**From:** "Greg W. Halsey" <GWHalsey@tigheBond.com>  
**To:** Jean Fraser <JF@portlandmaine.gov>  
**Date:** 7/7/2015 5:47 PM  
**Subject:** FW: Public comments - Proposed Neighborhood Center - 1342 Congress Street

2. The attached letter arrived today from Margaret Gaertner on behalf of the Libbytown Neighborhood Association. Her main concern (starts on second page) appears to be the front elevation- she mentioned this to me before but I told her the architect was still working on it. Could you please forward her letter to the applicant and the architect, as it would be good to have some kind of "response" in the PB Report. **We are very appreciative with the feedback provided us from the Libbytown Neighborhood Association in their letter to the Jewish Community Alliance of Southern Maine dated June 30, 2015. With respect to the concern raised regarding the elevation of the front façade of the community hall, and the desire for additional embellishment, we offer the following. The form of the community hall is being carefully designed to consider the appropriate scale at both a vehicular and pedestrian level on the north corner of the site while responding to internal program dema

PROJECT NO:	J-0096
FILE:	J0096-SITE.dwg
DRAWN BY:	GMH
CHECKED:	BLM
APPROVED BY:	BLM
SCALE:	AS SHOWN
	C-2B

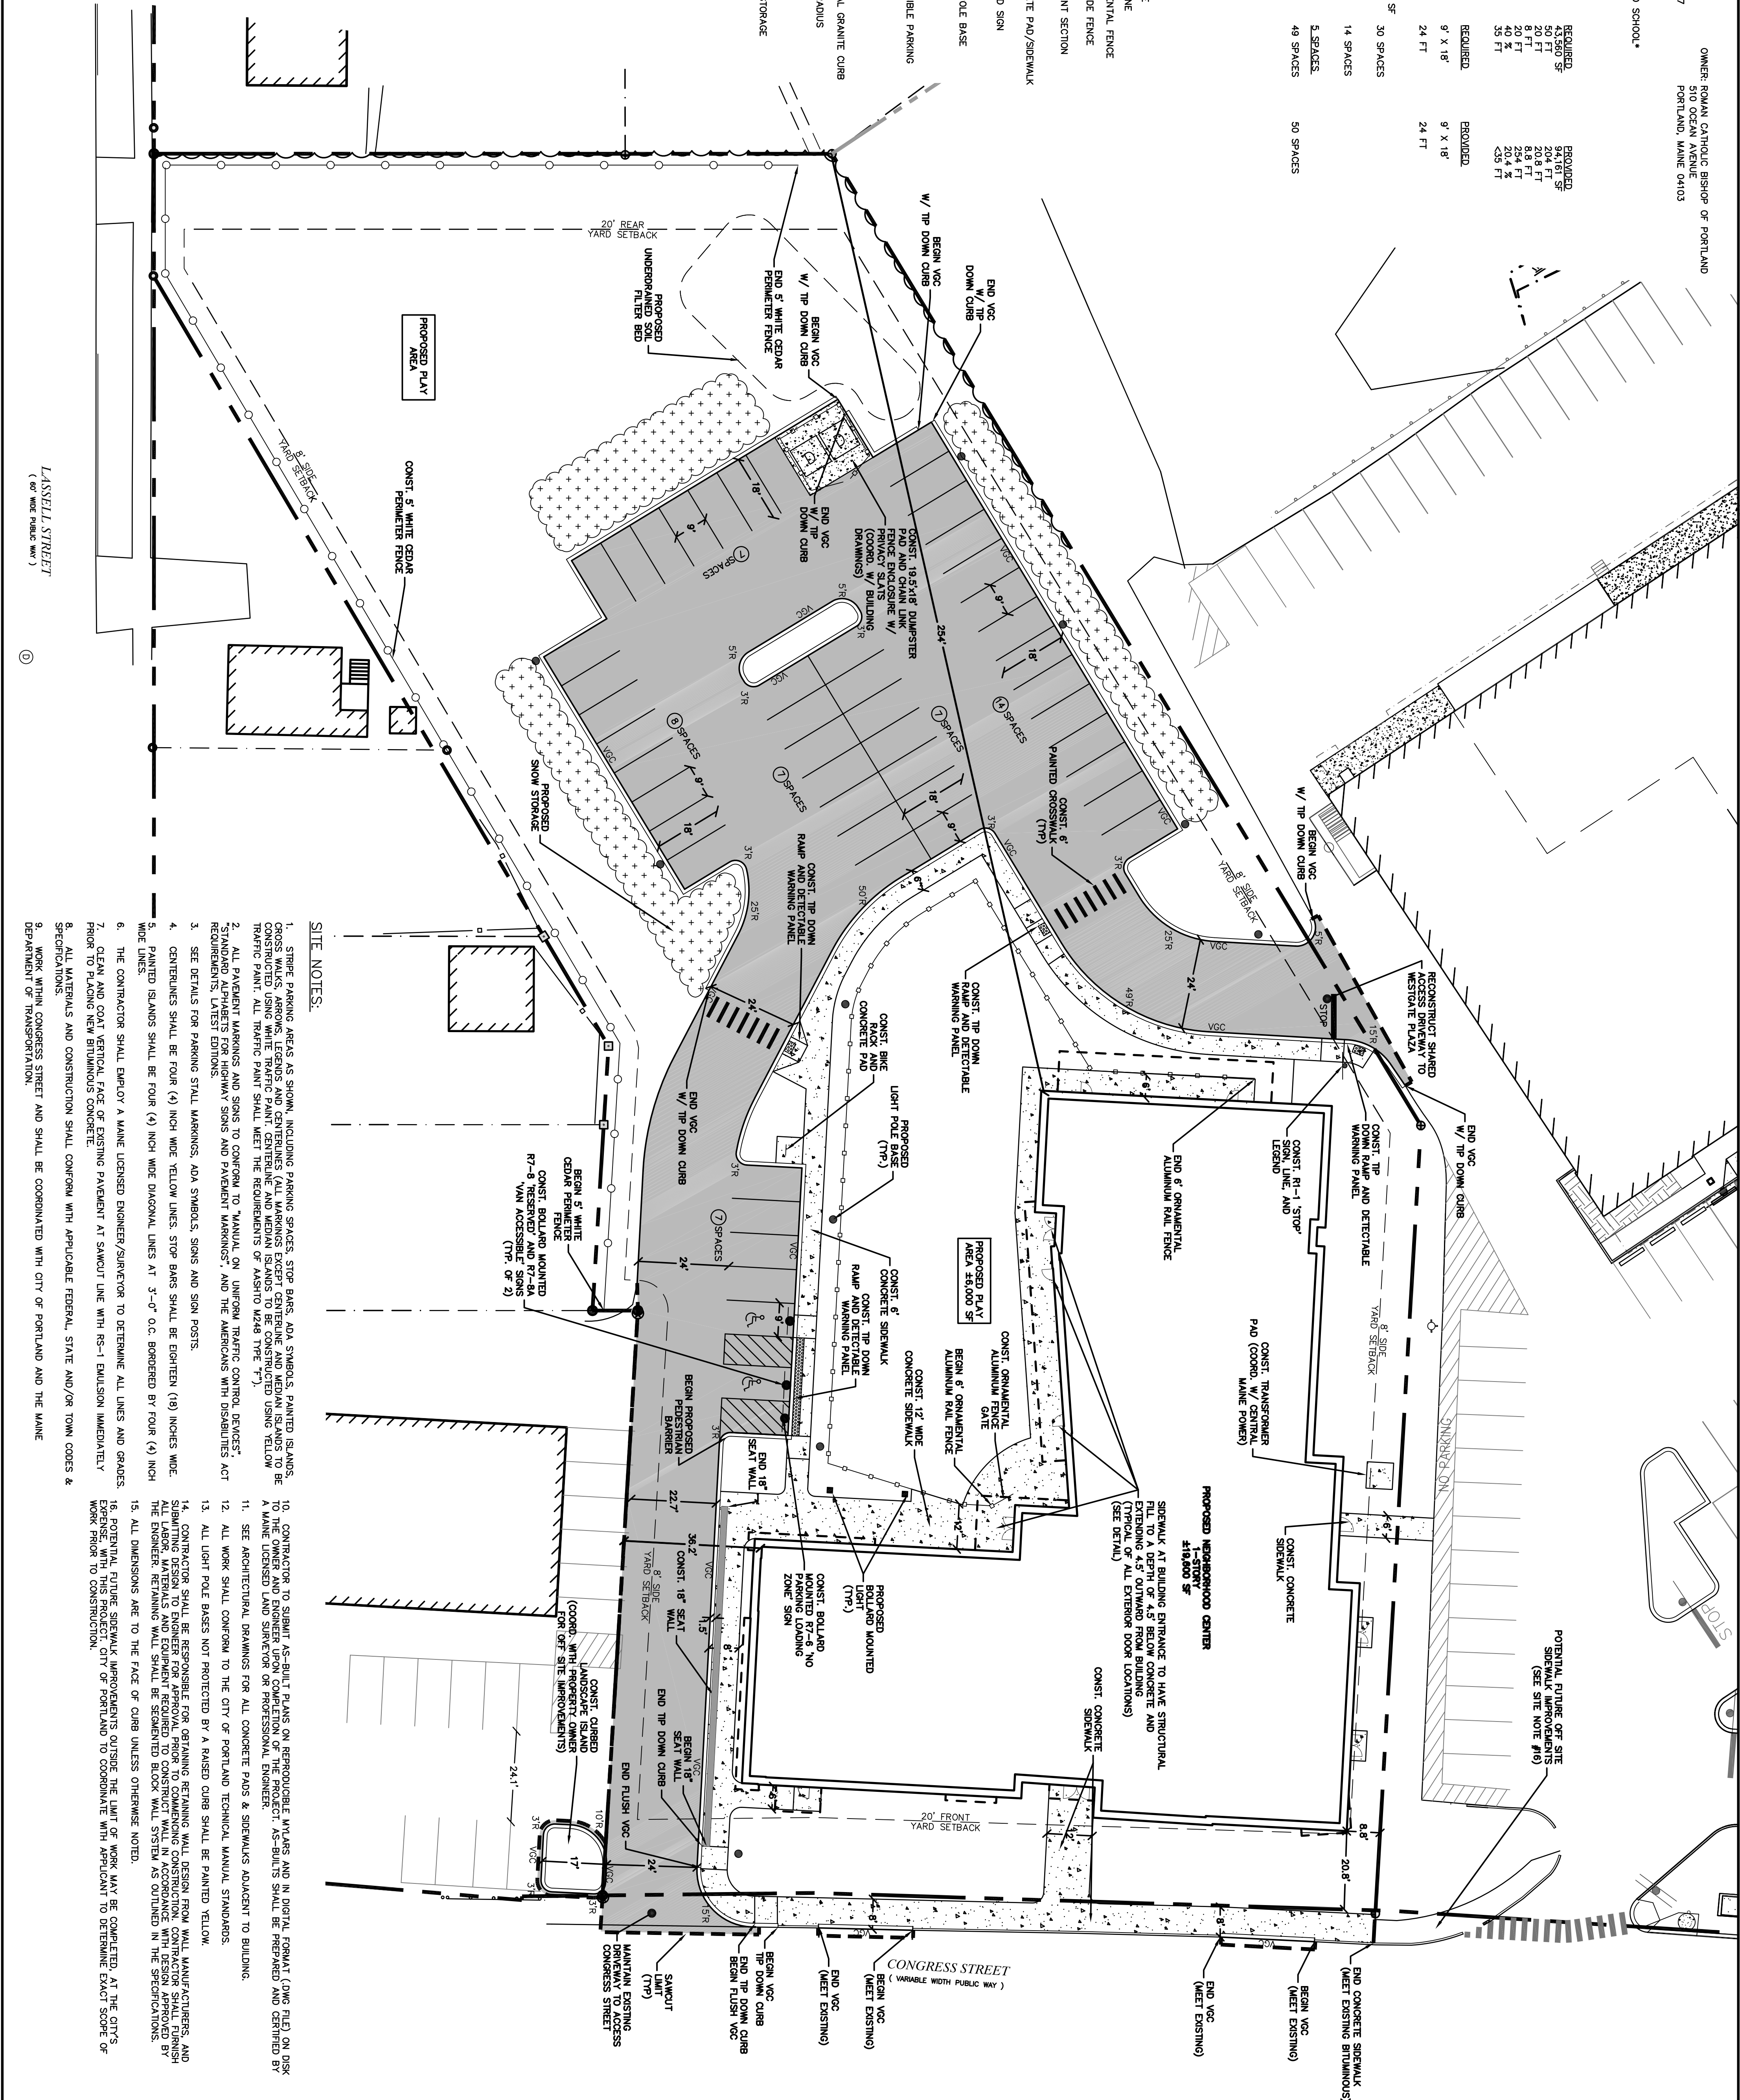
1. The property owner next to the dental offices- she has written to ask a number of questions but her main concern seems to be the 6 ft high stockade fence. I spoke with reviewers and we think that fence is necessary but could/should be lower and I said that I would raise that with you. **The Applicant has worked hard to provide both substantial landscaping and a wooden fence to buffer the proposed development from their residential neighbors. The proposed 6' tall cedar stockade fence was also recommended by the City Arborist in the Staff Memorandum prepared for the Planning Board Workshop. The fence will enhance the vegetated screen while providing an appropriate aesthetic appearance for the residential area that typically has 6' tall fences between properties. However, the Applicant will review the request to decrease the height of the fence to determine if a fence shorter than 6' will provide the appropriate screening required given the project's location abutting the residential properties.**
